From: Laura Gibbons <Laura.Gibbons@arun.gov.uk>
Sent: 20 October 2020 14:28
To: Planning.Responses <Planning.Responses@arun.gov.uk>
Cc: Anita Gardner <Anita.Gardner@arun.gov.uk>
Subject: M/72/20/DOC- Land West of Yapton Road (Poultry Farm)

Comments on Condition 11- Surface Water Drainage Design

Comments on Condition 13- Discharge of Flows to Watercourse and Culverting

<h2 style="text-align: center;">DRAINAGE DETAILS</h2> <h3 style="text-align: center;">SHEET 1 OF 2</h3> | | | | |

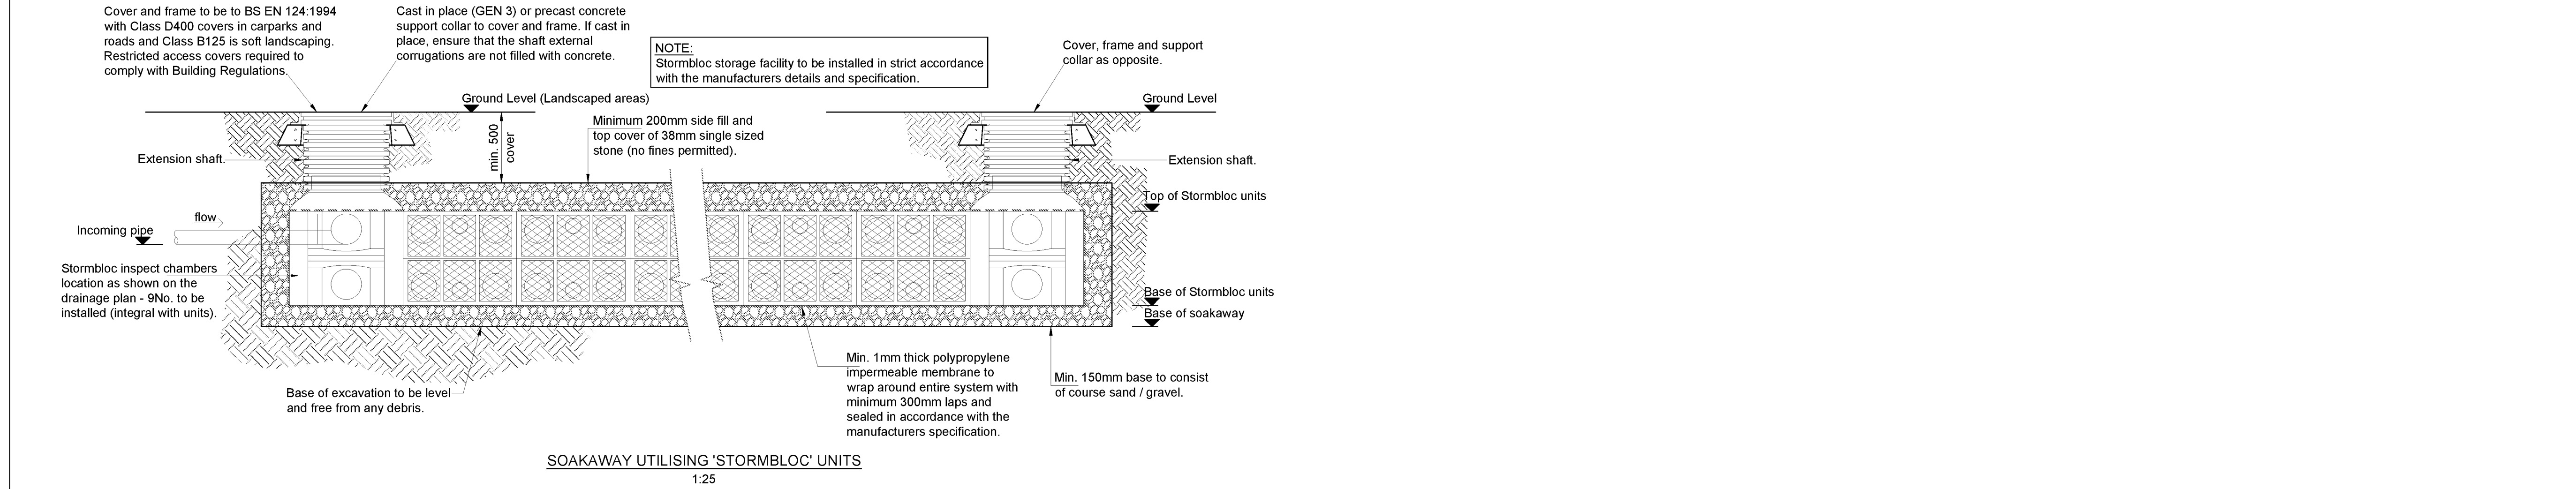
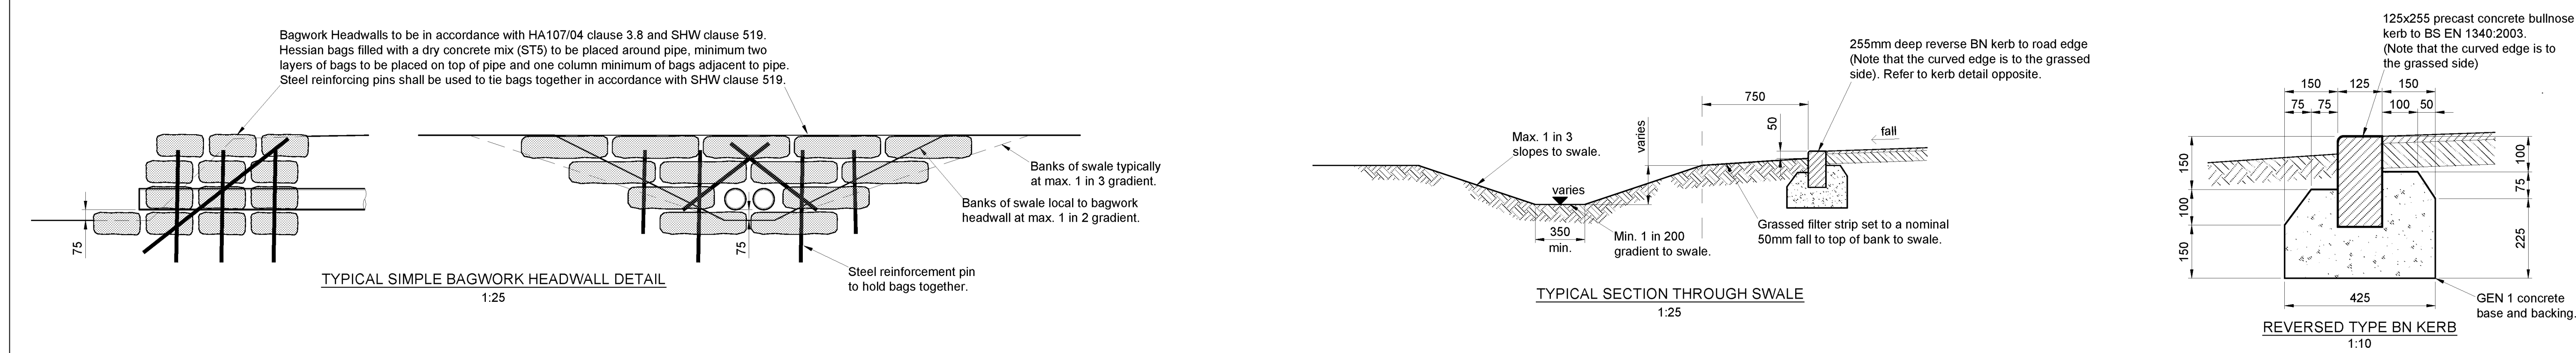
The discharge rate on plan is inconsistent with that in calculations. Please update and ensure that the full hydrobrake reference number is detailed on layout and construction detail drawings.

Please provide construction detail drawings of the proposed outfall to watercourse, clearly showing bed level, bank profile and top of bank level.

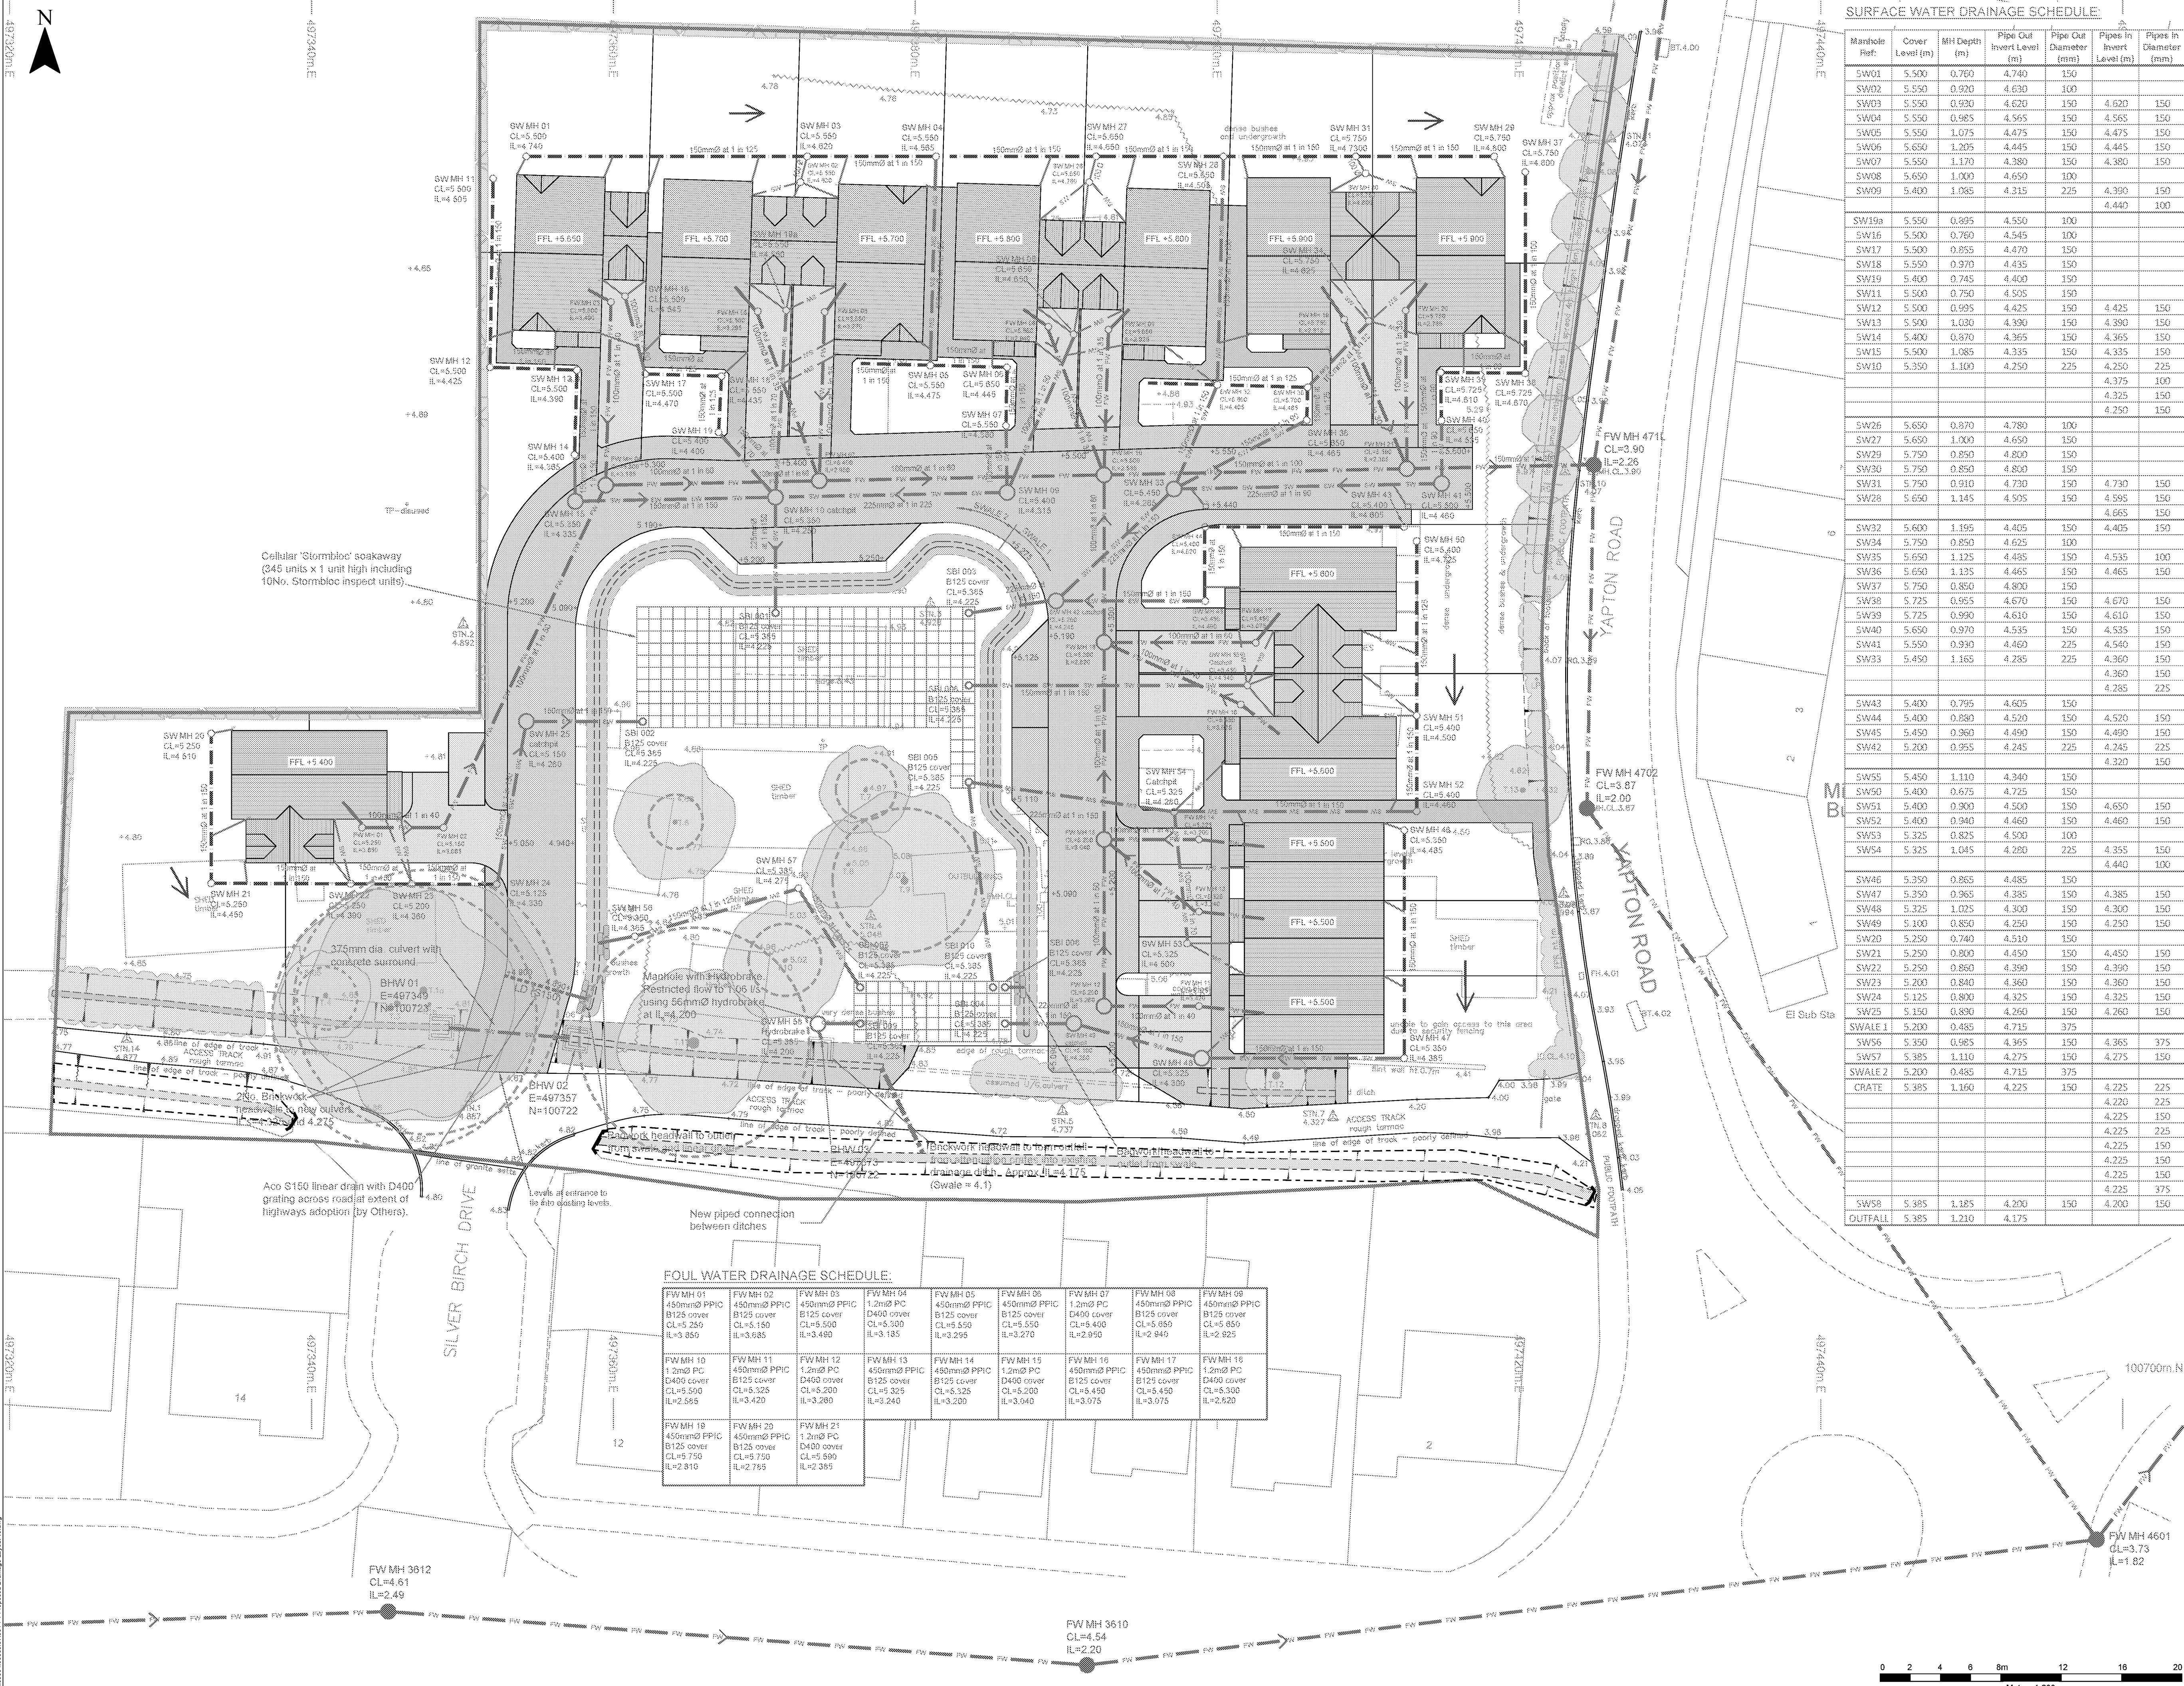
1. Please provide an impermeable areas plan so that calculations can be verified.
2. The proposed outlet invert level is at 0.075m above ditch bed level. Can this be raised? Please also provide further details of bed levels throughout the ditch.
3. Attenuation crates are currently labelled as soakaways, please correct.
4. The discharge rate on plan is inconsistent with that in calculations. Please update and ensure that the full hydrobrake reference number is detailed on layout and construction detail drawings.
5. Please clearly mark invert levels of the proposed swale.
6. Please confirm on plan where sumps and catchpits are proposed.
7. Please provide a flow exceedance plan.
8. Please ensure all construction detail drawings are up to date.
